Your Ref: MP 09\_0187 MOD 2

6 September 2013

**RE: SECTION 75W REQUEST TO FURTHER MODIFY APPROVED MIXED  
USE DEVELOPMENT PROJECT AT 6-16 ATCHISON STREET, ST  
LEONARDS (MP 09\_0187 MOD 2)**

LEVEL4

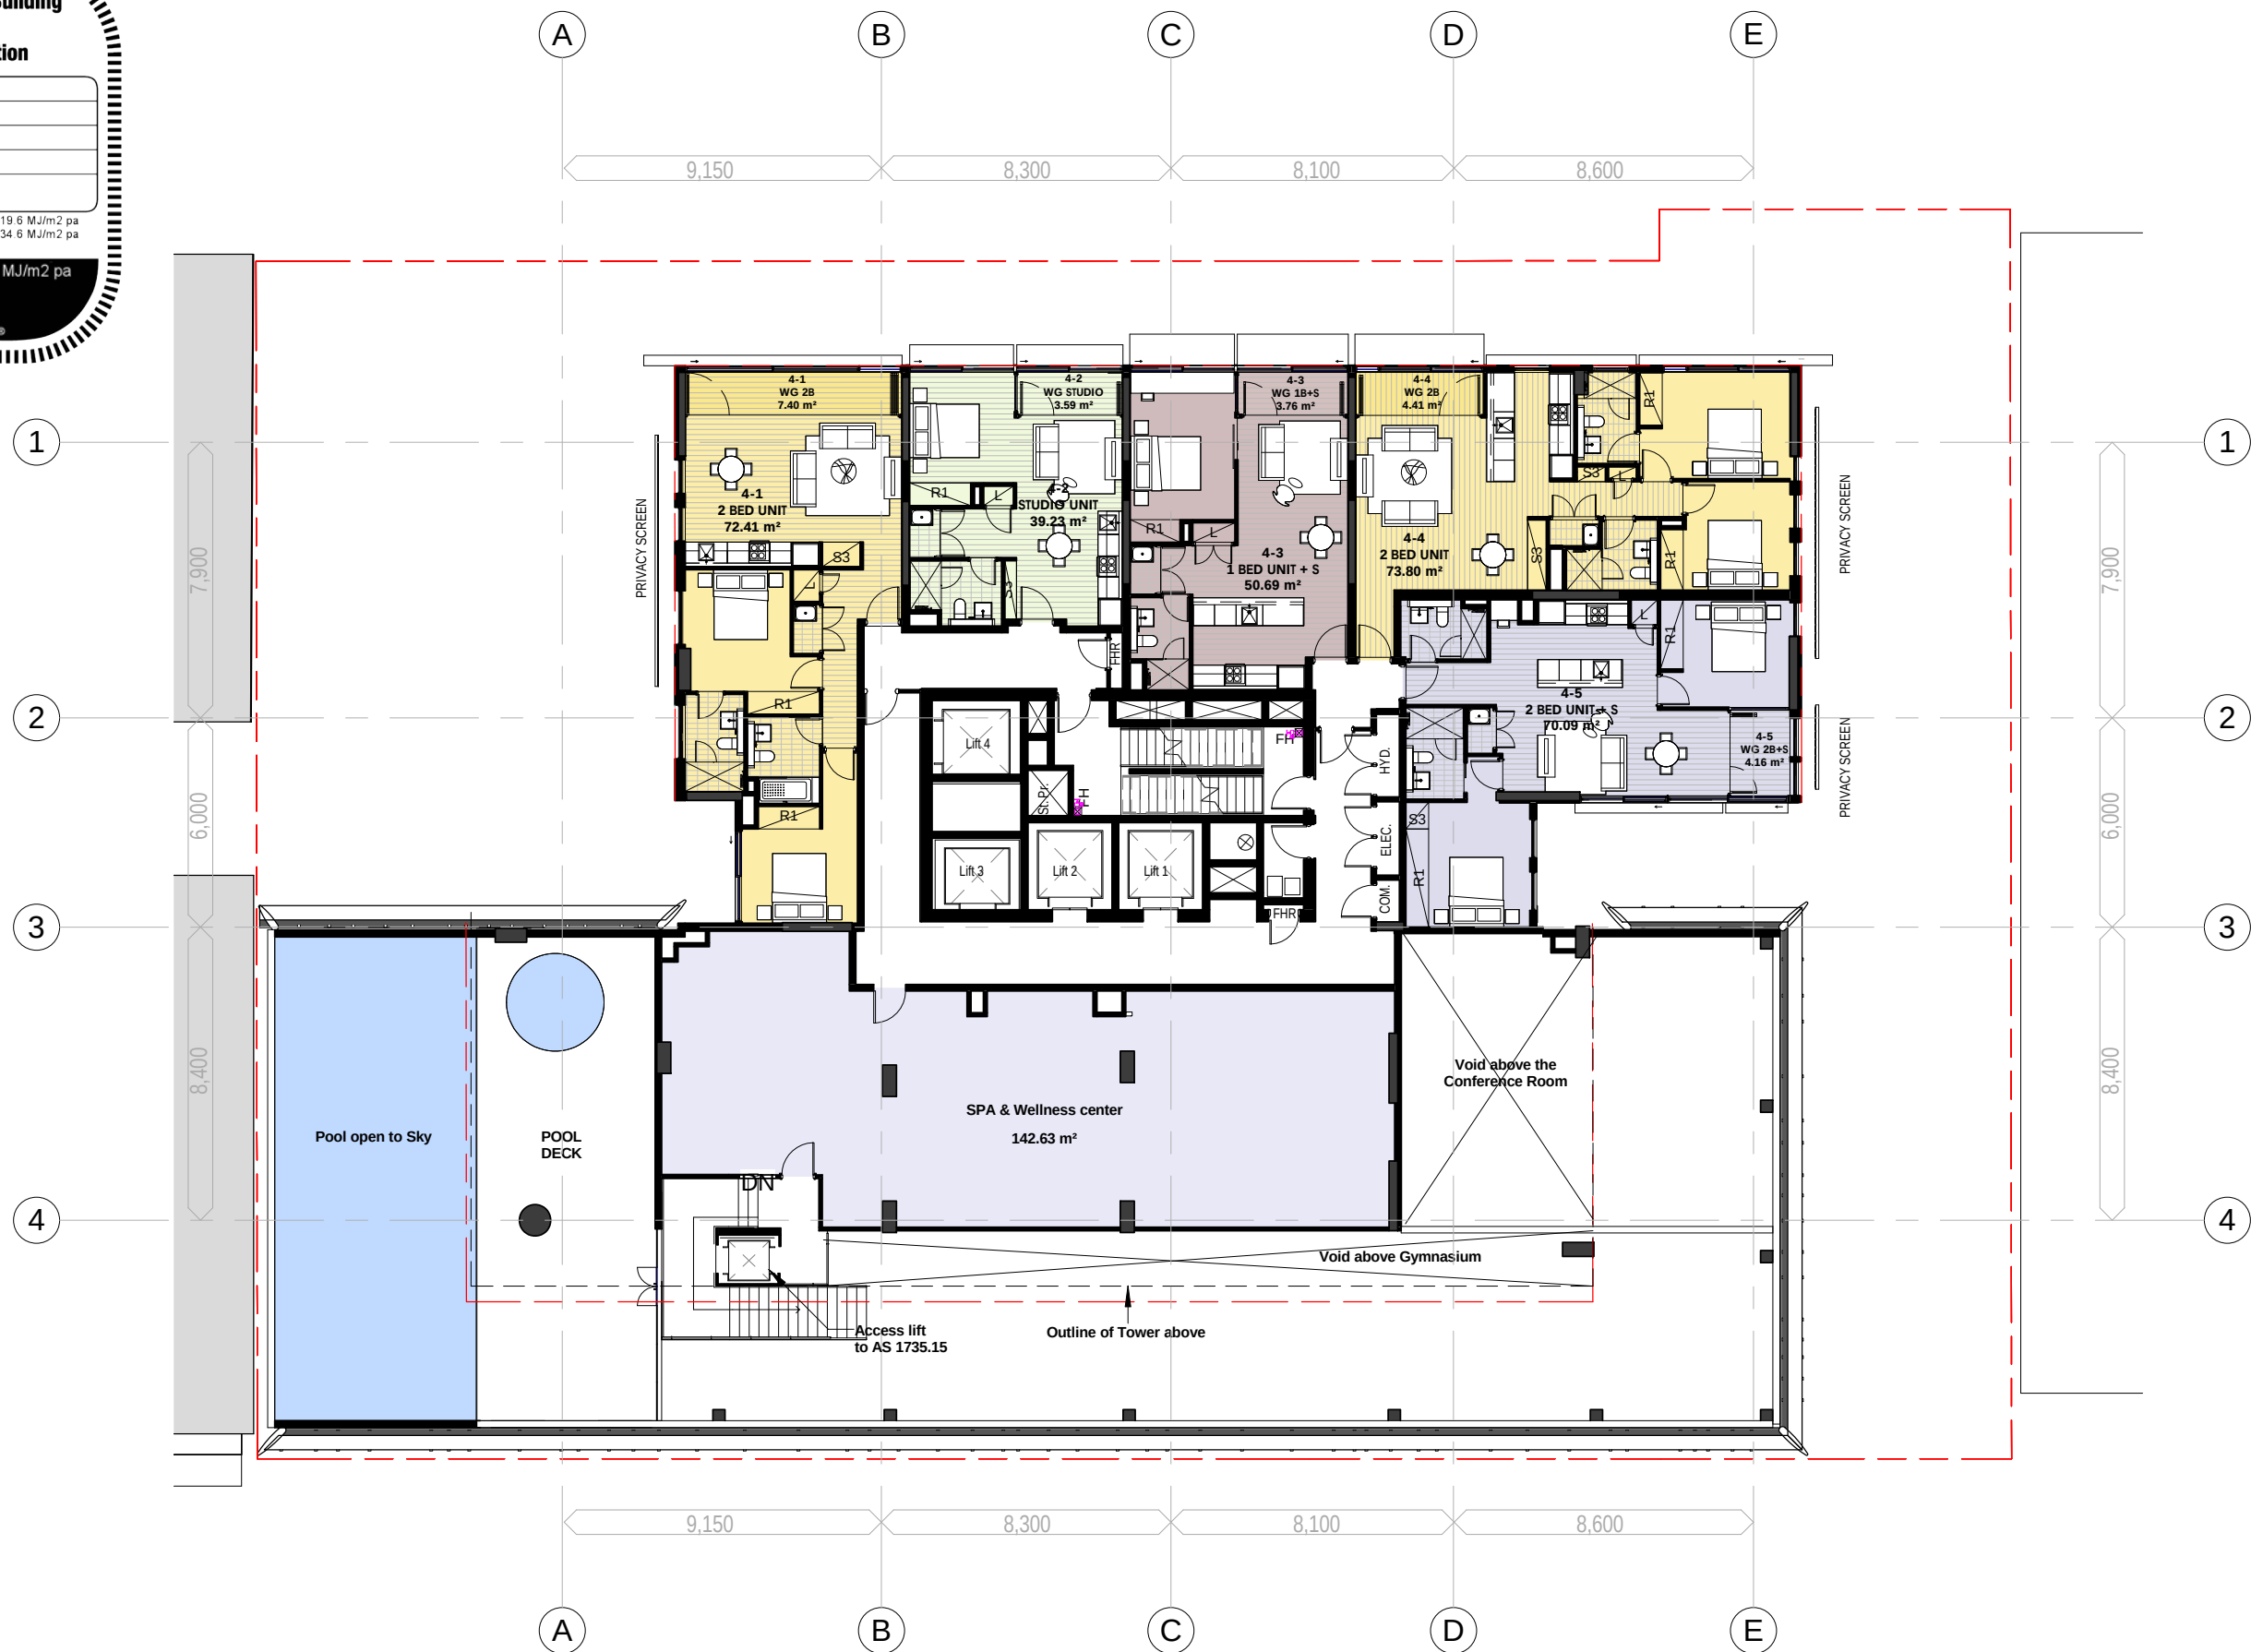
The site is zoned Mixed Use and it is important that the minimum non residential floor space requirements are achieved. Council recommends that the residential apartments on levels 3 and 4 form part of the serviced apartments as hotel and non residential floor area.
